23/7/18
A/11/18/DOC

From: Charlotte Burrows
Sent: 26 July 2018 15:35
To: Julia Mills
Subject: FW: URGENT - RE: A/23/18/DOC - Broadlees, Dappers Lane, Angmering
Attachments: RE: A/23/18/DOC - Broadlees, Dappers Lane, Angmering

Subject: URGENT - RE: A/23/18/DOC - Broadlees, Dappers Lane, Angmering

TREE PROTECTION (Plan 3A)

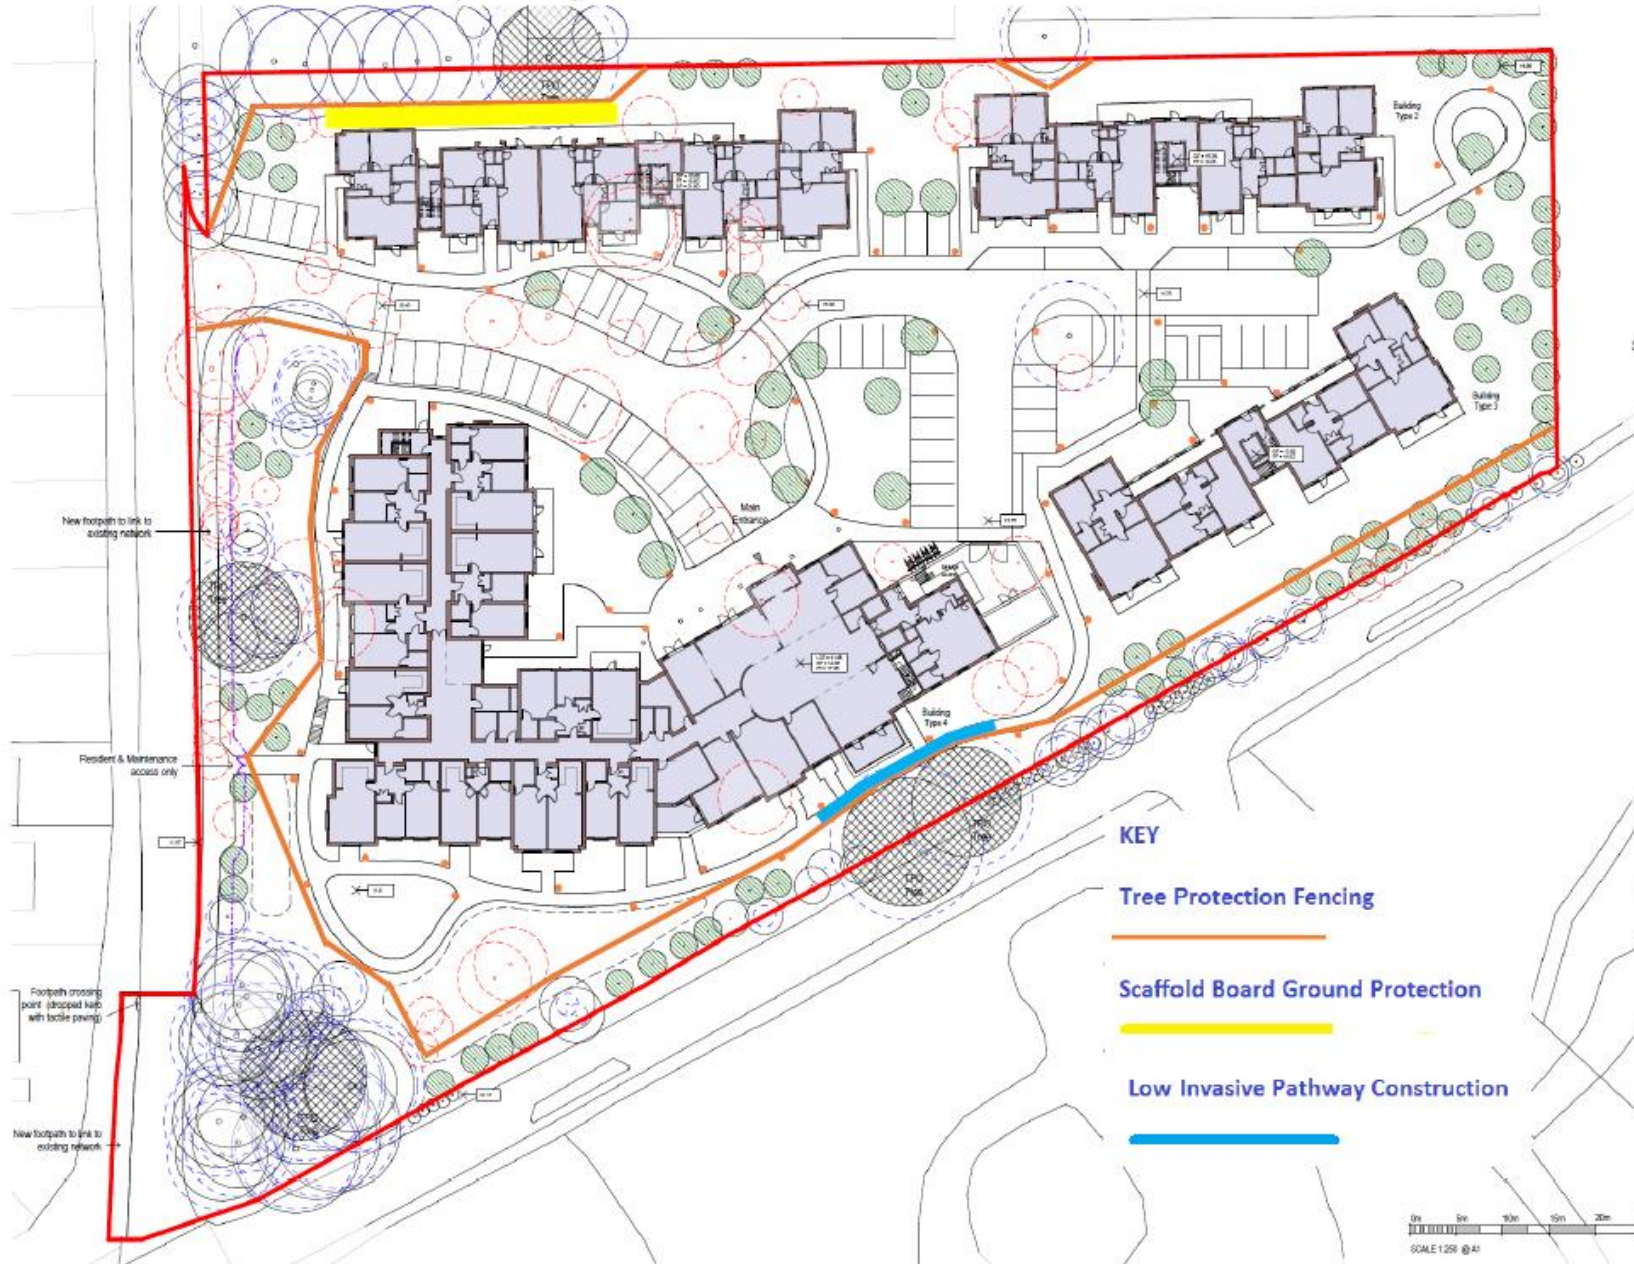
At the present time NO vegetation clearance has taken place and NO protective fencing has been erected.

In the absence of general vegetation clearance and erection of Protective Fencing the Condition has not been complied with and I am therefore unable to sign it off at this time.

I note that the applicant has submitted a Tree Protection Plan Ref: Plan 3A – the measures set out on this plan are acceptable but will need to be implemented and then a Pre-Commencement Meeting can take place [at a mutually convenient time] between the applicants representative and the Arun DC Tree Officer to agree that the Protective Fencing complies with BS5837 recommendations and is 'Fit For Purpose' and that it has been erected exactly as shown on Plan 3A".
